From: Anita Gardner
Sent: 05 December 2018 17:05
To: Karen Parsons
Subject: FW: FG/171/18/DOC - Peugeot Garage Premises, Littlehampton Road,

From: Carol Reynolds
Sent: 04 December 2018 13:33
To: Anita Gardner
Subject: Re: FG/171/18/DOC - Honda Garage Premises, Littlehampton Road,

Environmental Health: Application for discharge of conditions. Further information required.

DRAWING TITLE
Proposed external lighting scheme

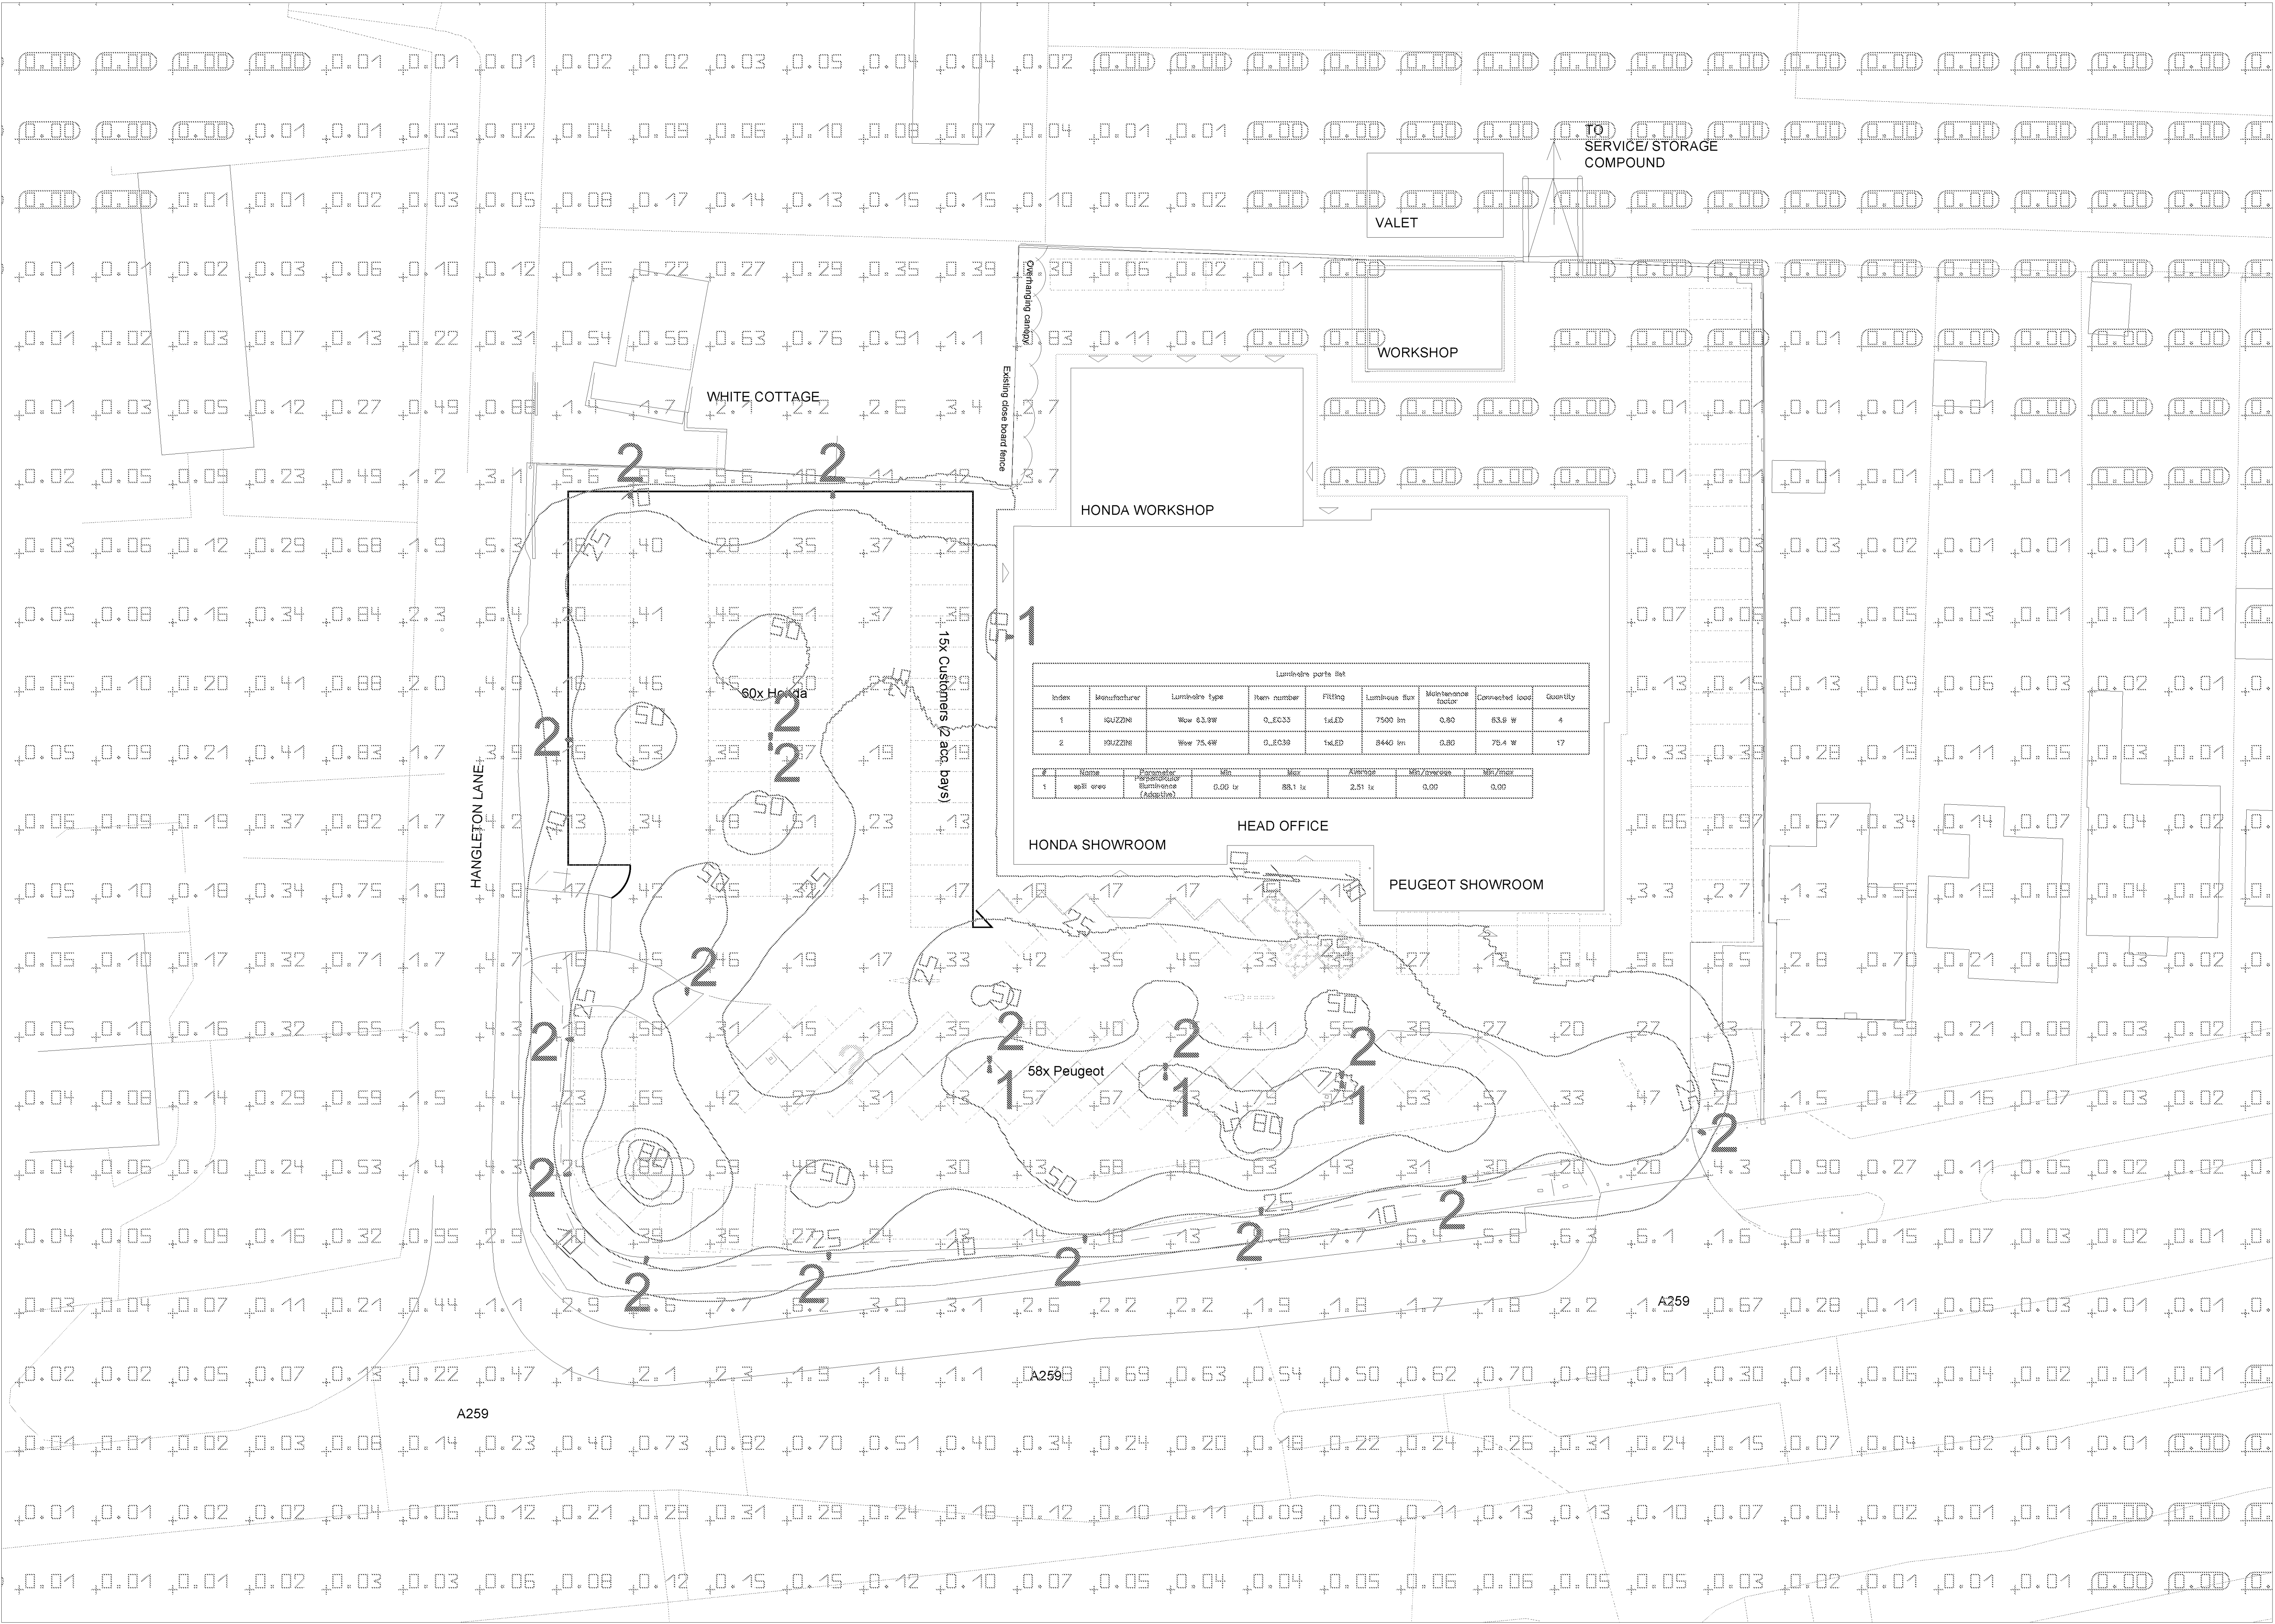
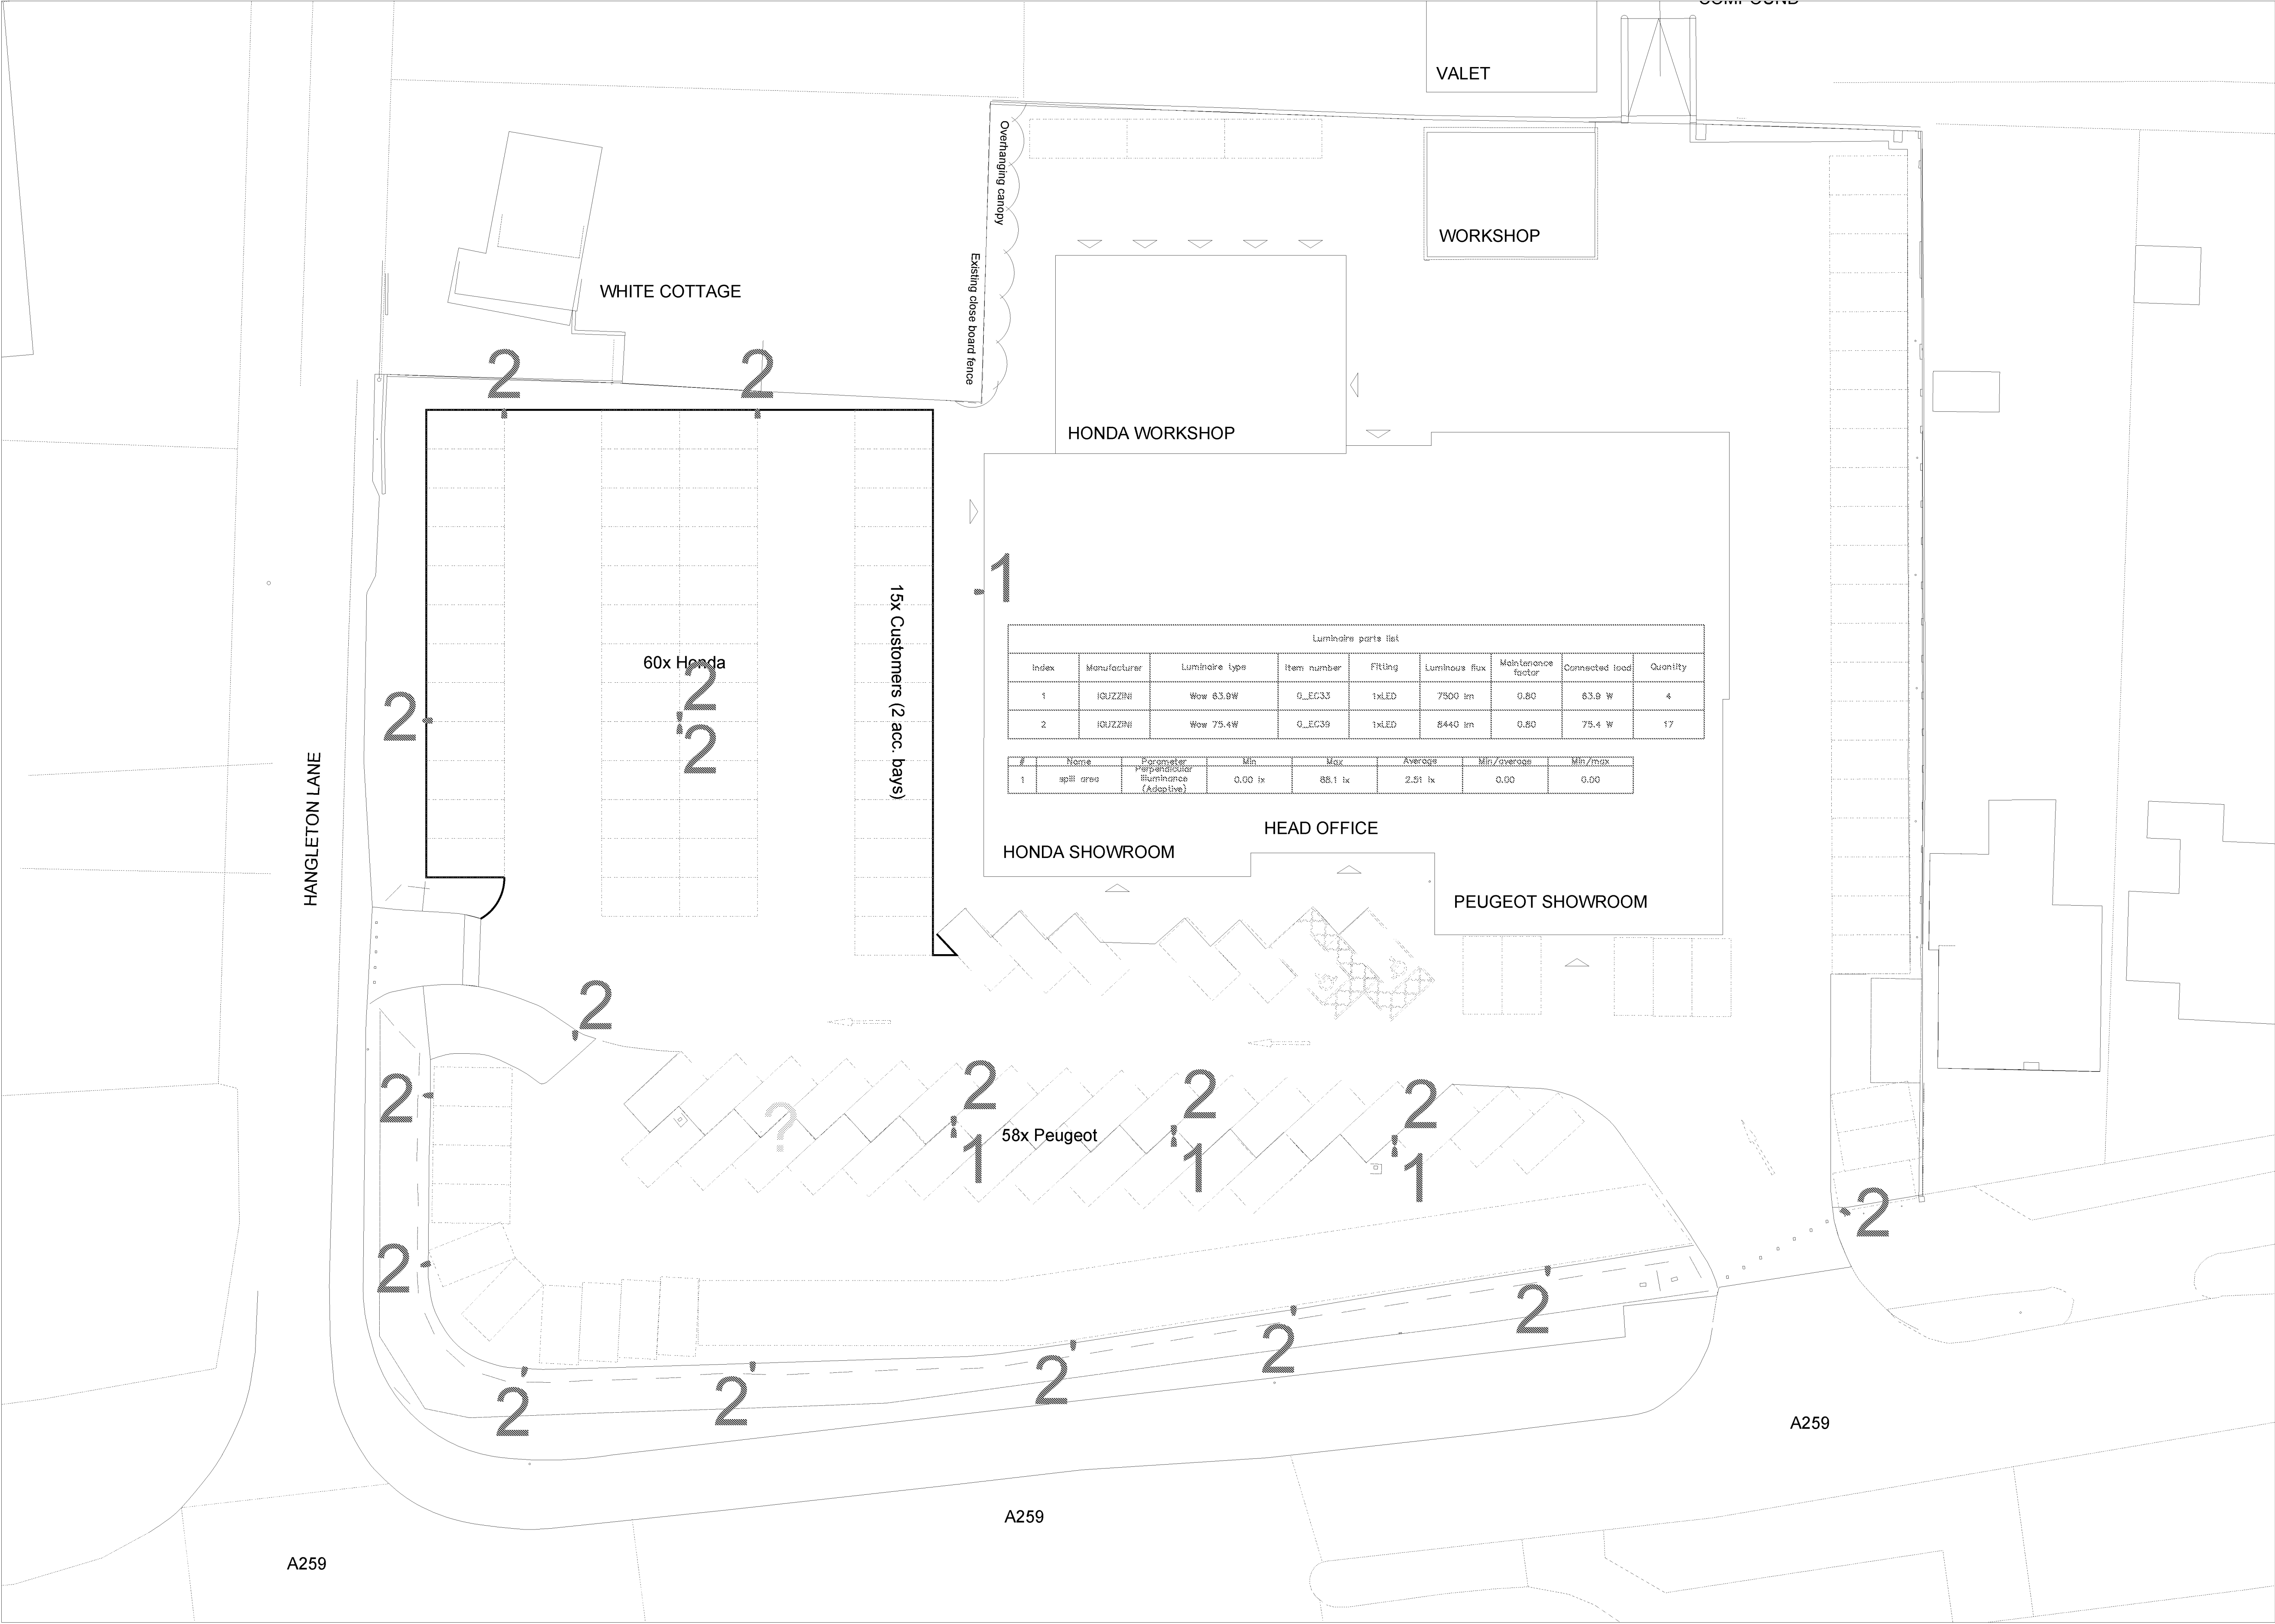
Regarding the lighting design issues, I believe our Electrical Engineer will contact either yourself or the EH officer directly, as they currently don't understand what is being asked of the design.

Lighting Plan: Lower level lighting, specified as 'Type 1' to be provided to areas proximal to sensitive receptors and to the north of the site in order to prevent detriment to the amenity of these properties and South Downs National Park.
